250439 - 81-83 George St & 1 Barrack Ln, Parramatta - Response to DoE Comments – R2

TO: Katherine McIntosh **DATE:** 20 March 2026
COMPANY: Mecone
EMAIL: kmcIntosh@mecone.com.au
FROM: JackL@pwna.com.au
SUBJECT: 81-83 George St & 1 Barrack Ln, Parramatta – Response to DoE Comments – R2

The following memorandum provides Pulse White Noise Acoustic's (PWNA) responses to Department of Education (DoE) comments on the previously submitted Noise and Vibration Impact Assessment (NVIA) (Ref: 250439 - 81-83 George St & 1 Barrack Ln, Parramatta - SSDA Acoustic Assessment - R8, dated 7th November 2025).

Figure 1 Map identifying locations of heritage items and proximity to site.

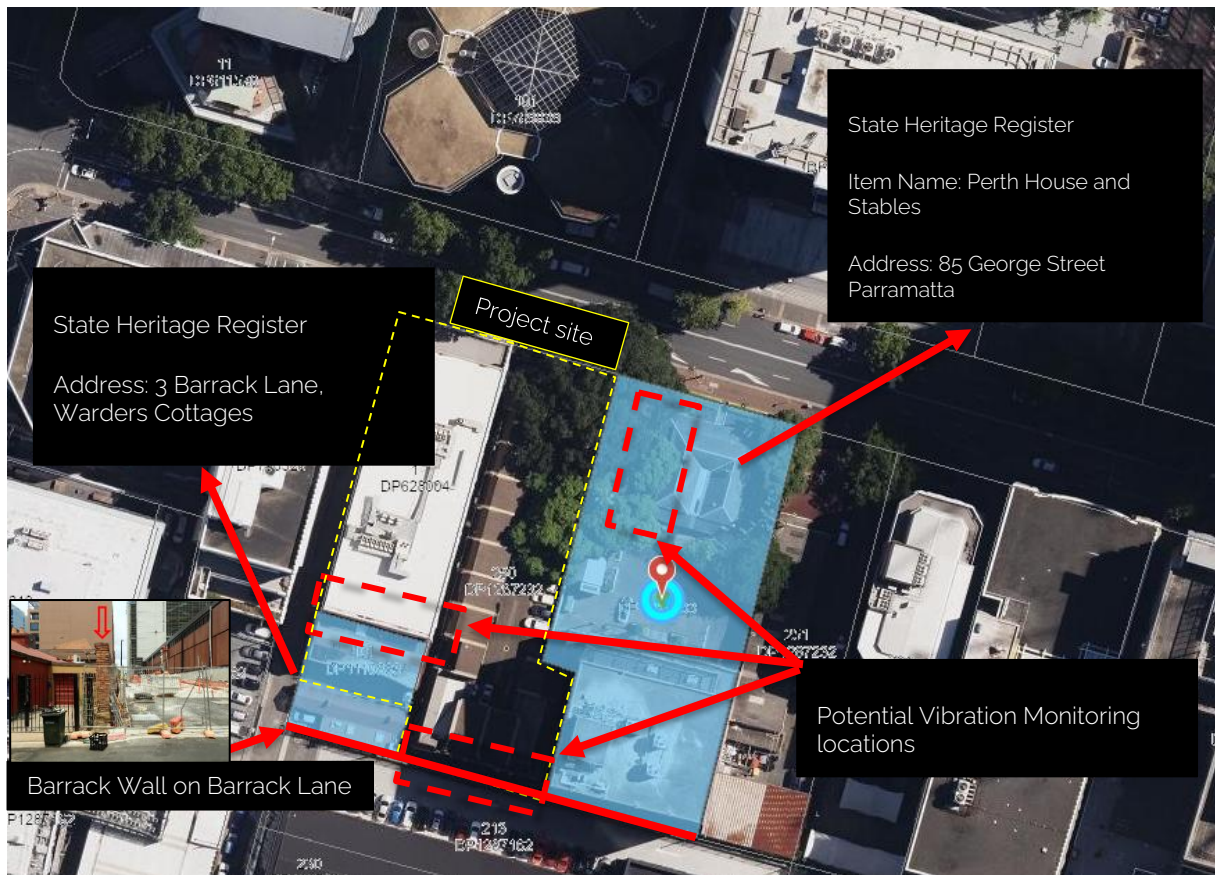
Inclusion in the Heritage Impact Statement and proposal of measures to conserve and protect the shared heritage item of the Convict Barracks wall. A 3m setback for the development will enable future access to the wall but does not address the construction impacts of such major works on the wall, and it is considered that the impact statement did not provide adequate controls for construction works to preserve it in its current condition. As the convict wall represents the boundary between the department's property and the proposed development, impacts to this heritage significant structure would also have operational impacts to the boundary of the school; a 3m exclusion zone is completely inadequate to prevent these impact.

Given the close proximity of the site to the identified heritage items, the vibration criteria, mitigation measures, monitoring requirements, and management recommendations set out in the submitted Noise and Vibration Impact Assessment (NVIA) are also intended to apply to the heritage items identified below in Table 1.

A review of the State Heritage Inventory and Schedule 5 of the Parramatta Local Environmental Plan (LEP) 2023 was undertaken to identify the listed Heritage items. These heritage items are indicated in Figure 1 below.

The NVIA specifically addresses vibration impacts on establishing minimum safe working distances for construction plant and activities. These distances are based on accepted cosmetic damage criteria from BS 7385: Part 2 and DIN 4150: Part 3 (refer Table 20 of the NVIA). The site specific minimum working distance should be validated prior the start of the construction work for any identified heritage items.

For the SSDA, a revised, project-specific Construction Noise and Vibration Management Plan (CNVMP) is recommended to be prepared prior to Construction Certificate (CC) approval. The CNVMP shall incorporate appropriate vibration management measures, including monitoring at the heritage items, consistent with the intent of the previous plan.

Heritage items located within close proximity to the site will be assessed by a structural engineer as part of the pre-construction surveys. In the event that an item is deemed structurally unsound during these surveys, then the more stringent DIN4150 heritage criteria will be applied to this item.
